THE SHOPS FILING NO. 2 AT MERIDIAN RANCH LOT 2

SITE DEVELOPMENT PLAN
EL PASO COUNTY, COLORADO.
FALCON, COLORADO

DRAWING NO.
COVER
SITE DEVELOPMENT PLAN

DRAWING NO. 1
SITE DEVELOPMENT PLAN

DRAWING NO. 1  
SITE DEVELOPMENT PLAN

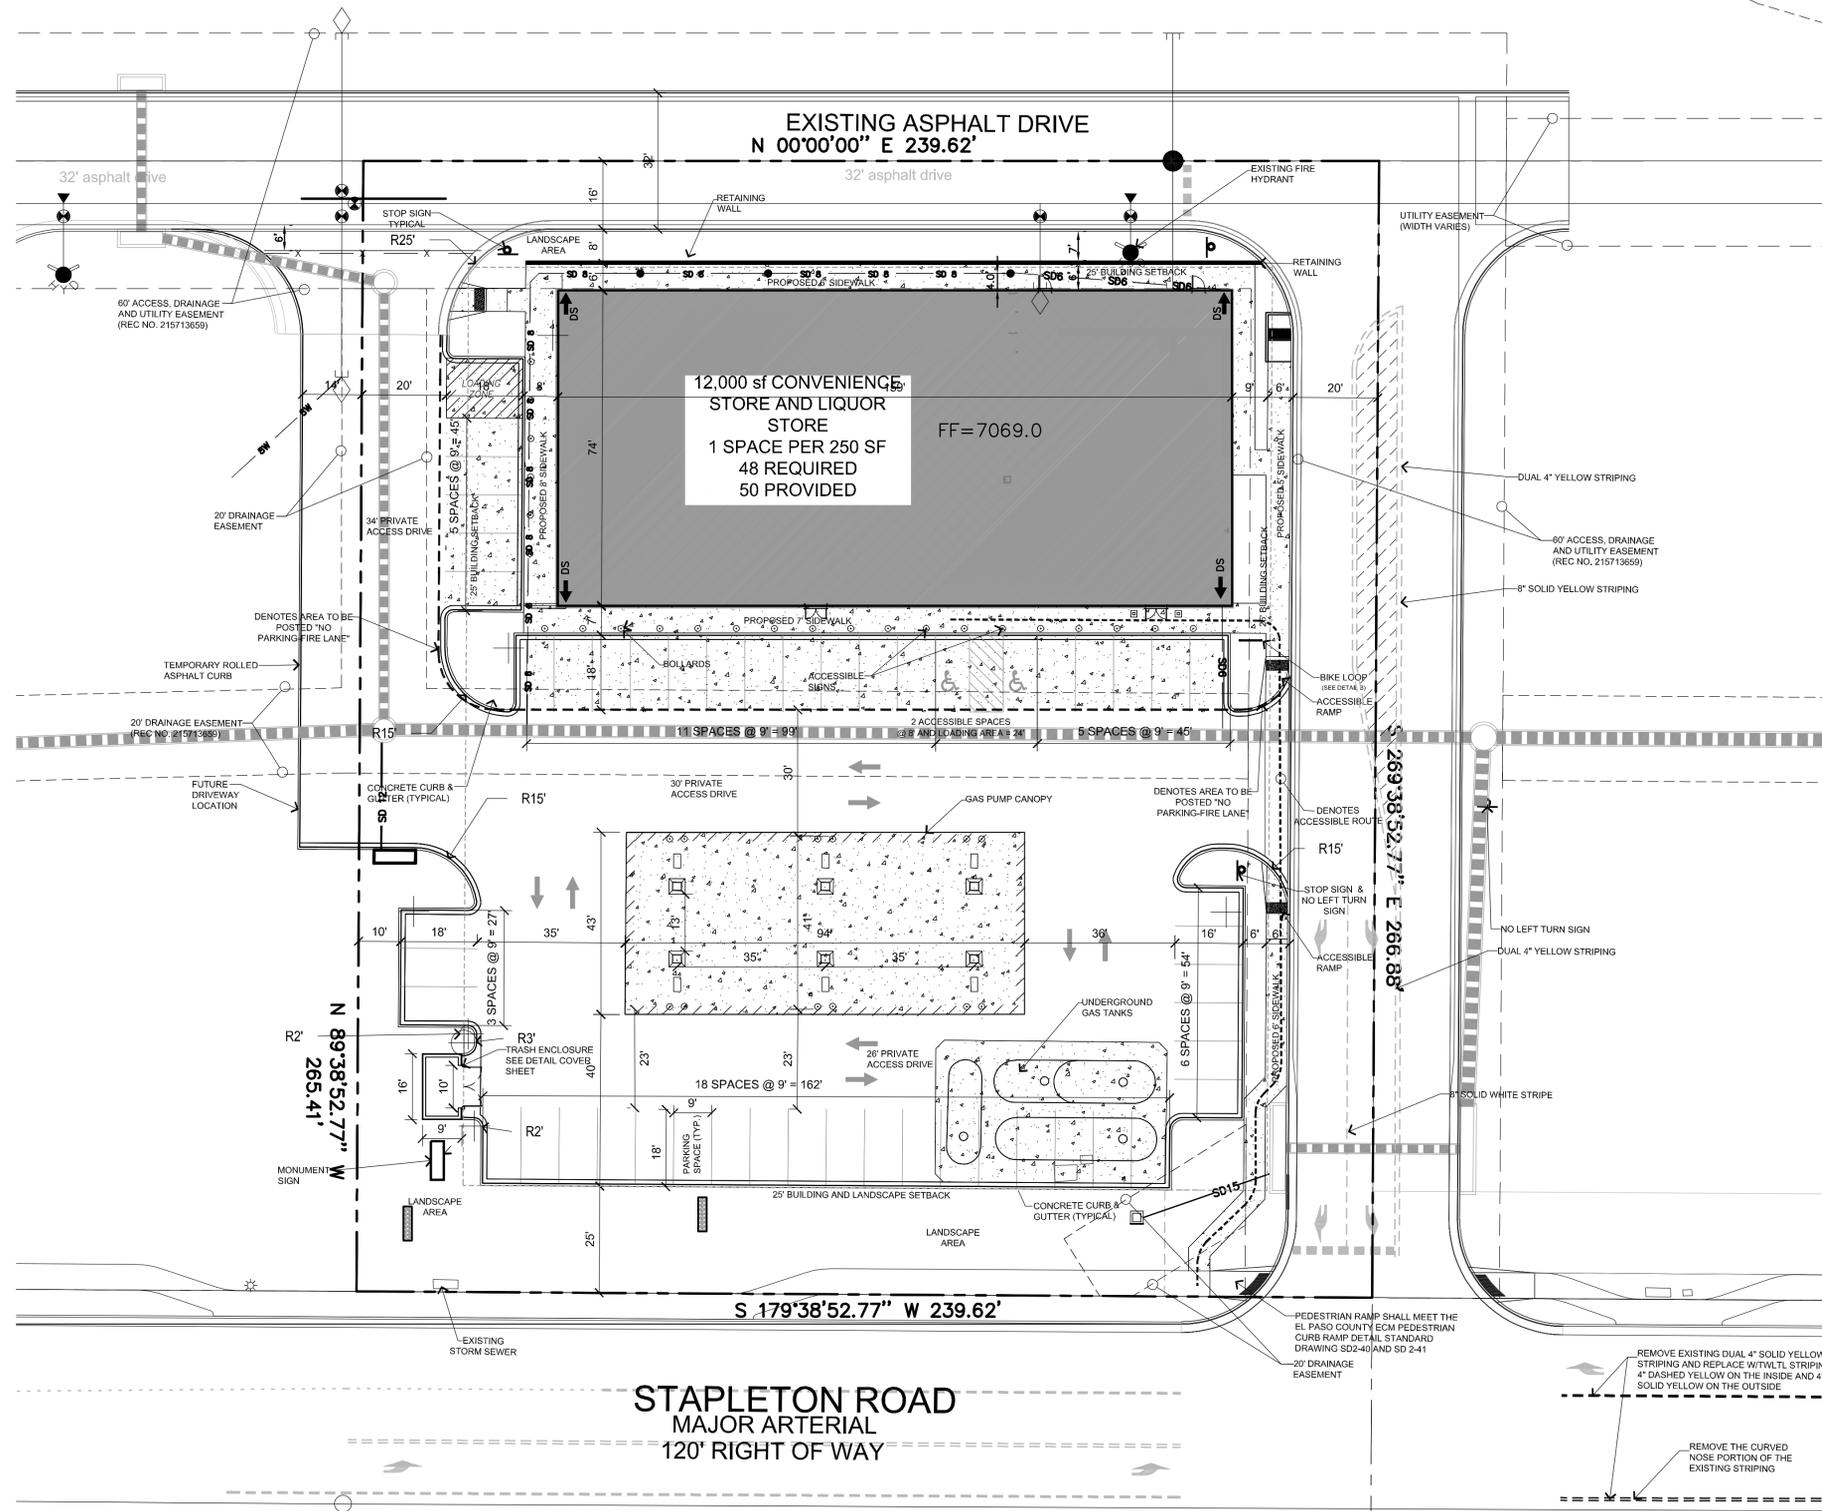
Previous comment not addressed. Parking spaces adjacent to curbs appear to be 8 ft. Minimum width is 9 ft. for 90 degree parking spaces

Previous comments had asked for the building information to be updated. Per the 1" = 20' scale, this building is approx. 11,827 sq. ft. Please ensure the measurements are accurate, as this will impact the parking requirements.

Include the previously identified note that the gas canopy has a 25 ft setback.

This calculation still doesn't include the gas canopy which is a structure.

Previous comment not addressed. Update this with the correct square footage calculations and the correct uses, which are GAS STATION and COMMERCIAL CENTER, LESS THAN 10 ACRES.

GAS STATION PARKING CALCS are 1 space per employee on maximum shift, plus 3 spaces per bay or stall IN ADDITION to the 1 space per 250 sq. ft. for the commercial center. You need to identify the max number of employees and the number of gas pumps in order to provide the parking calculation.
